**KIRKLEES METROPOLITAN COUNCIL
INVESTMENT & REGENERATION SERVICE**

DELEGATED DECISION TO DETERMINE PLANNING APPLICATIONS

Reference No:	2024/62/91580/W
Site Address:	3, Weatherhill Crescent, Birchencliffe, Huddersfield, HD3 3QZ
Description:	Erection of two storey front and side and part single storey rear extension, single storey porch to front, dormer to rear, timber cladding, construction of retaining wall to create tiered garden and associated alterations
Recommending Officer:	Joanna Rednall

DECISION - REFUSED

East Elevation

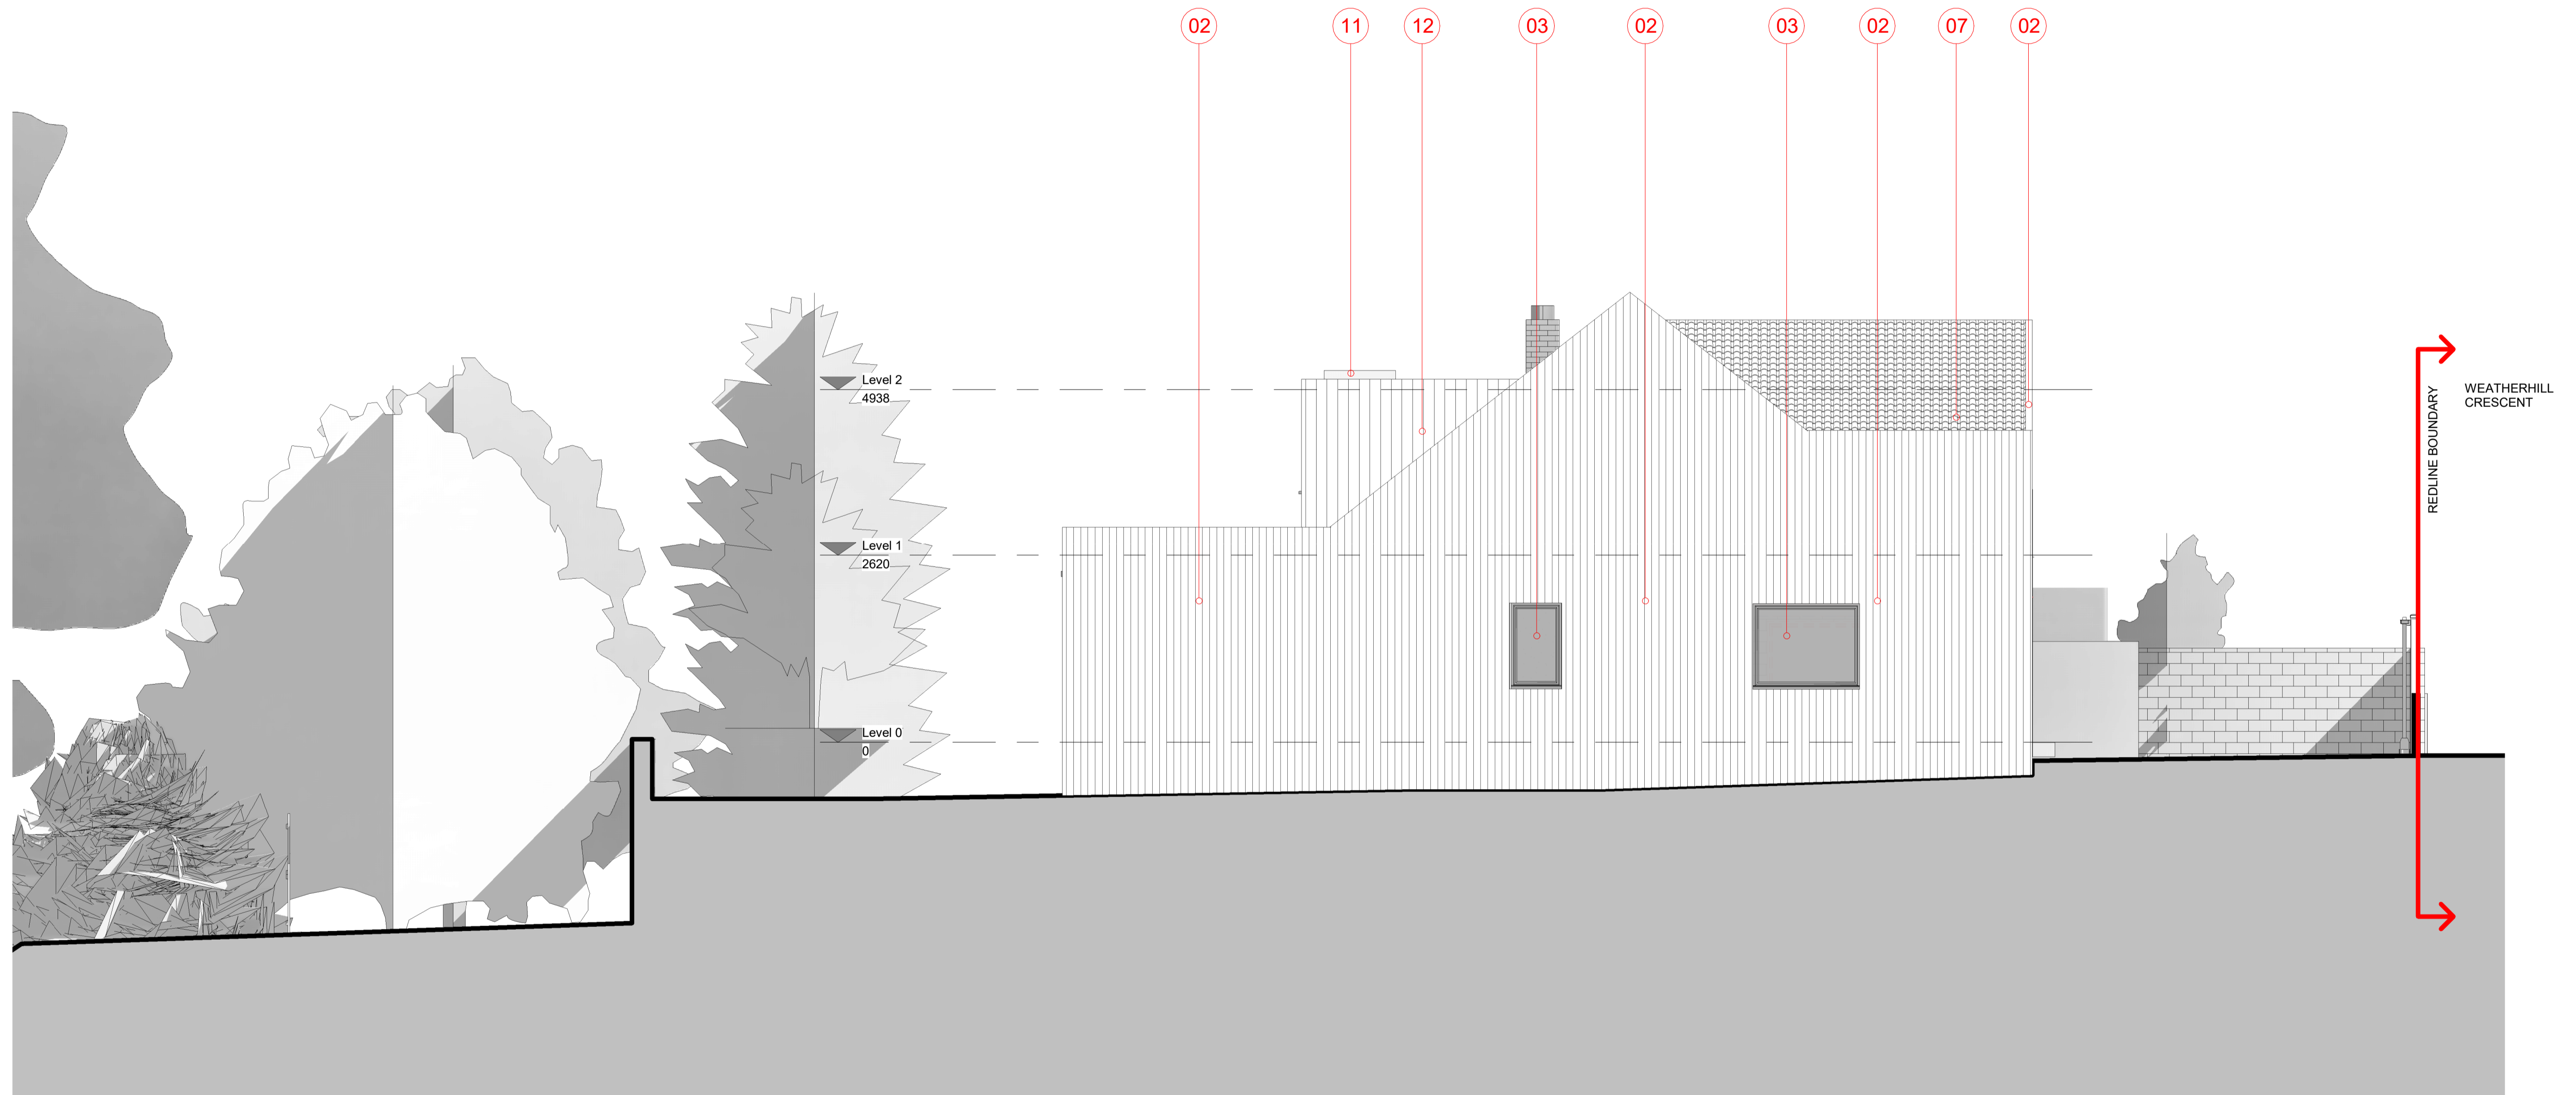
The design of the proposed two-storey side extension to 3, Weatherhill Crescent would be contrary to the design principles of the House Extension and Alterations SPD as set out above. The two-storey side element of the extensions would not appear as a subservient addition to the host property, presenting an undue extent of additional bulk/massing to the front and side of the dwellinghouse.

The projection of the side extension would retain a separation distance of 0.5 metres from the side/east facing boundary and would project forward of the principal elevation of the host property by approximately 0.9 metres. Cumulatively, these two design factors would result in the extension appearing cramped and overly dominant within the row of semi-detached bungalows. It is acknowledged that the roof design would reflect that of the host, and the ridgeline is set down from the host dwelling. However, this does not overcome the significant concern that the overall design and scale is unacceptable in terms of visual amenity.

It is also acknowledged that the materials proposed would not match the original house. The proposed timber cladding is not reflective or in keeping with the material palette within the surrounding street scene. Significant glazing is proposed to the front elevation, further adding to the obtrusive nature of the proposed works.

The submitted plans show two windows to be inserted into the east-facing side elevation of the proposed side extension. Given these windows serve a garage and utility room, non-habitable rooms, they are not considered to be detrimental to the privacy of No.1 Weatherhill Crescent. A site visit also confirmed blank elevation to this wall of No.1, further working to mitigate any overlooking impacts.

West elevation

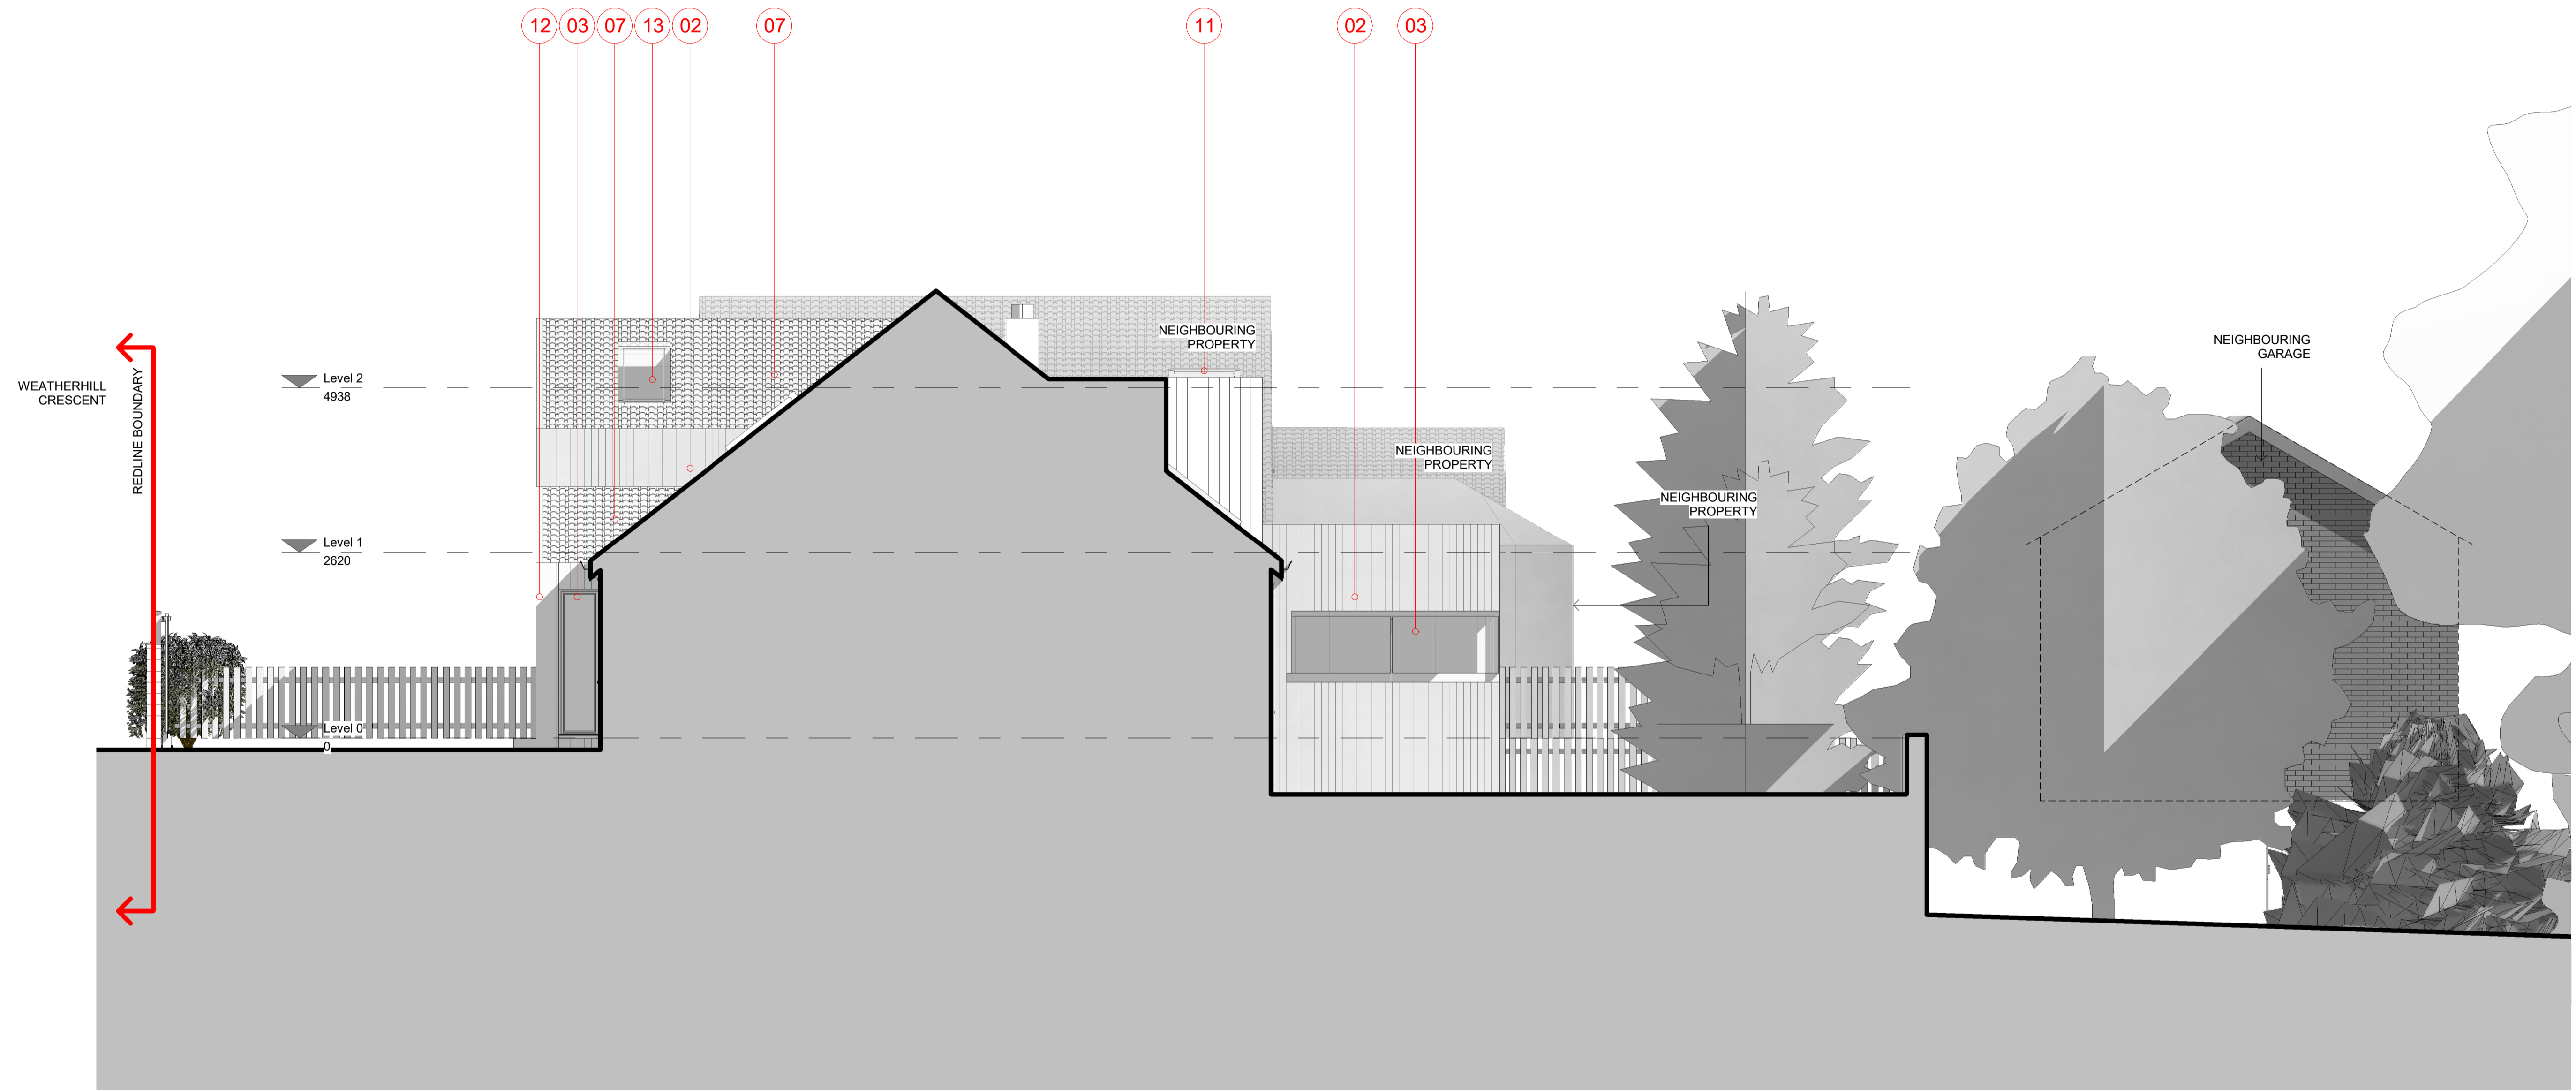
The proposal also seeks to provide a flat roof dormer to the rear roof slope of the existing dwelling. The property already benefits from a dormer to the rear of the property, adjoined to No.5. This dormer would be set back from the eaves of the roof by ~0.2 metres and set down from the ridge line by ~1.2 metres. The total width of the dormer would be approx. 5.8 metres and it would have a depth of around 3 metres. While the dormer is adequately set down from the ridge, the set back from the eaves is minimal and has a visually awkward appearance which would not form an acceptable relationship with the main house. The windows would also not be in alignment with existing dormer windows to the rear.

In addition, with the use of pressed metal cladding, the design of the rear extension would form an incongruous feature within the roof form and would not therefore be considered to be acceptable in terms of visual amenity.

Having taken the above into account, the rear dormer lacks any substantial gap to maintain a sense of space from the eaves, and the window openings would not be in alignment with the existing dormer windows on the host property and neighbouring properties. It is therefore considered that in terms of visual amenity, the proposed dormer extension would be contrary to Policy LP24 of the Kirklees Local Plan, the adopted House Extensions and Alterations SPD, and advice within the National Planning Policy Framework.

The proposed single storey rear extension would have openings facing this neighbour within the side elevation, sited approx. 8.2 metres from the conservatory at No.5. This distance is considered sufficient to meet the 45 degree rule from No.5's habitable windows, therefore would not cause undue harm to overshadowing/loss of light.

Retaining Wall Elevation
1 : 50

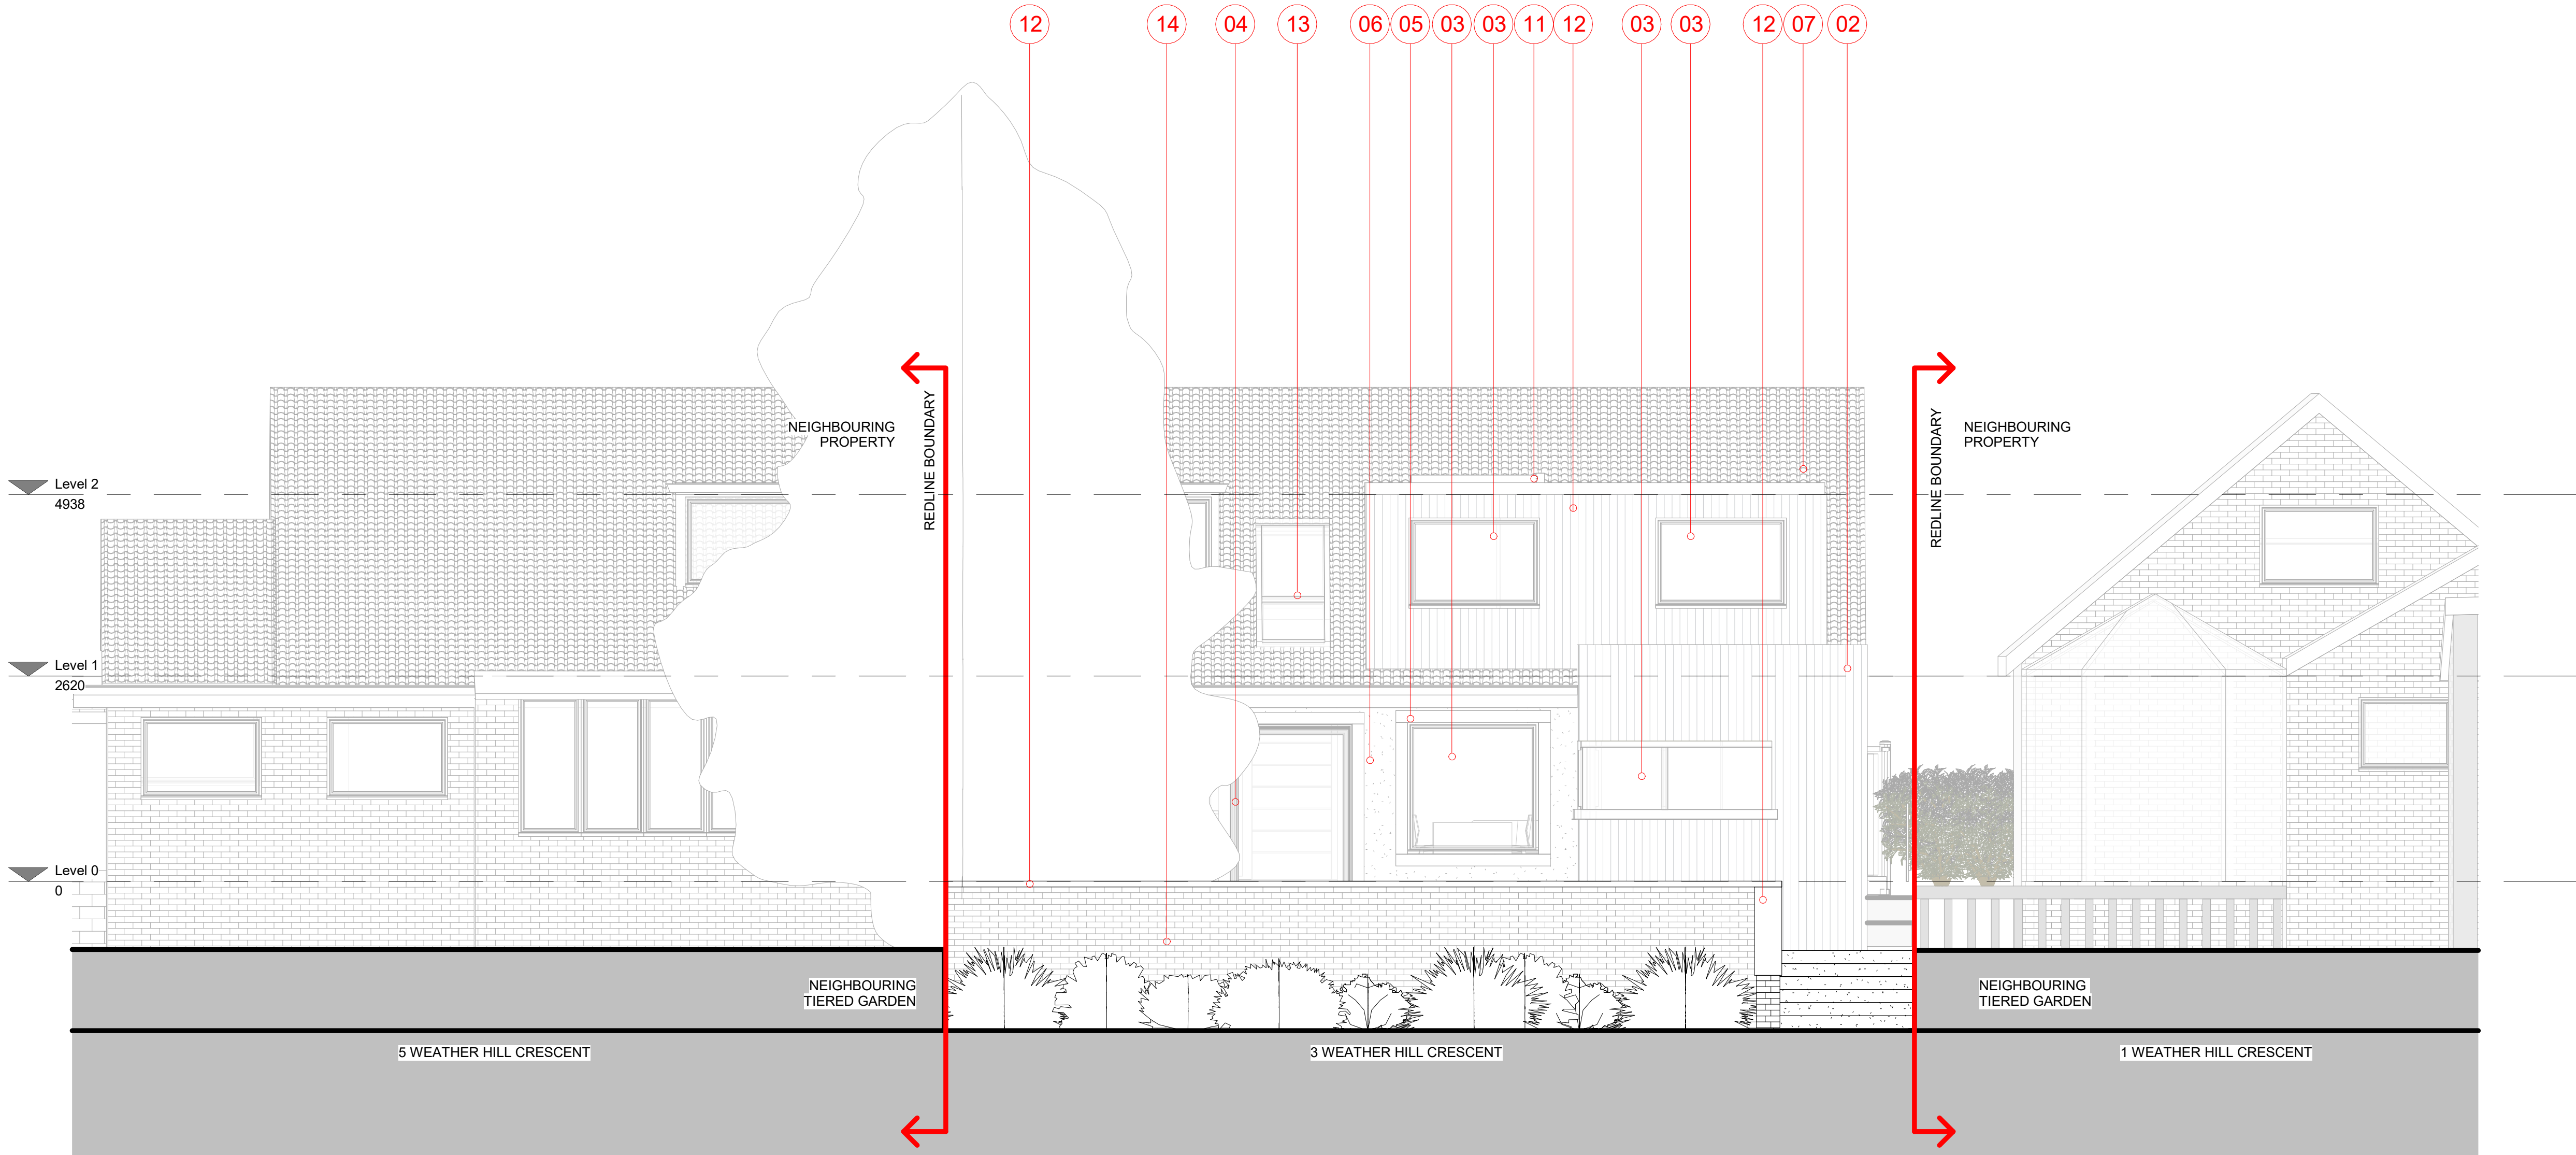
Due to the topography of the site, land levels decline to the rear of the garden. A retaining wall, approx. 4.3 from the rear elevation of the original house is proposed. The wall is approx. 1.9 metres in height with a length of 10 metres. The wall would be constructed from concrete tumbled stone and topped with pressed metal cladding. The retaining wall would be constructed from similar materials to existing boundary treatments within the local area, and the proposed plans note similar tiered gardens in neighbouring properties No.1 and No.5 Weatherhill Crescent. The proposed retaining wall to create a tiered garden is therefore considered acceptable in terms of visual amenity.
